PLAN REVIEW SHEET

Petition #: RZP 2020-160

Request: UR-2 (CD) and MUDD-O

**Aldersgate Rezoning #2020-\_\_\_**  
3800 Shamrock Drive  
Charlotte, NC 28215  
Date: 10/02/2020 Rezoning Submittal  
Project ID: 17048  
**Proposed Rezoning Technical Plan**  
**RZ-01**

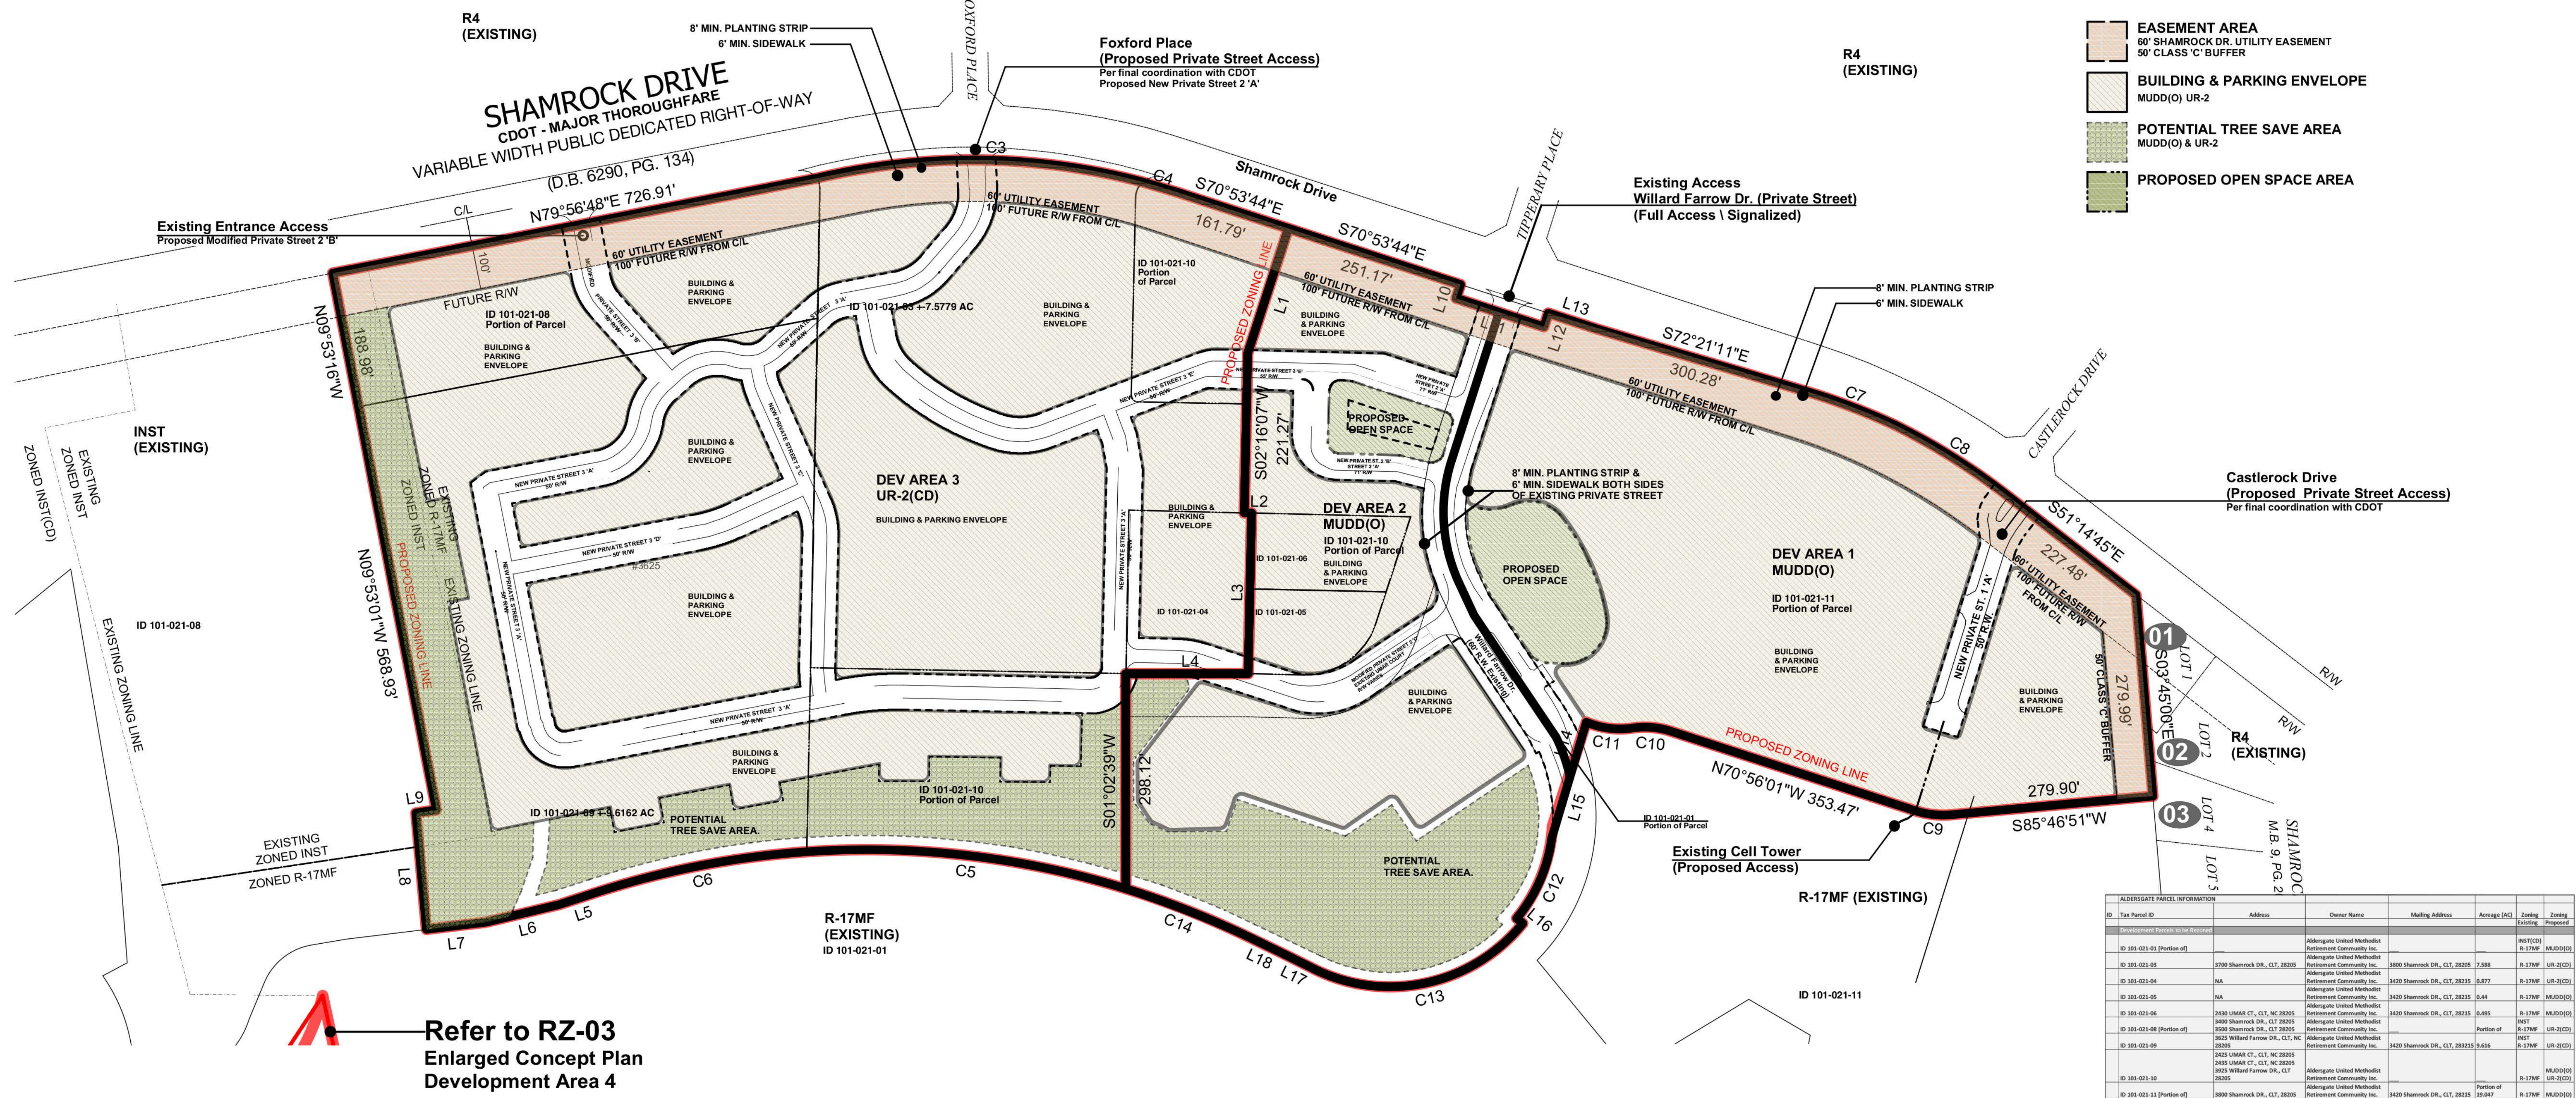
The site is located along CATS local bus route #23 on Shamrock Drive. CATS requests the petitioner to maintain the existing shelter (stop #27350), or build a suitable replacement according to CATS detail 60.04A.
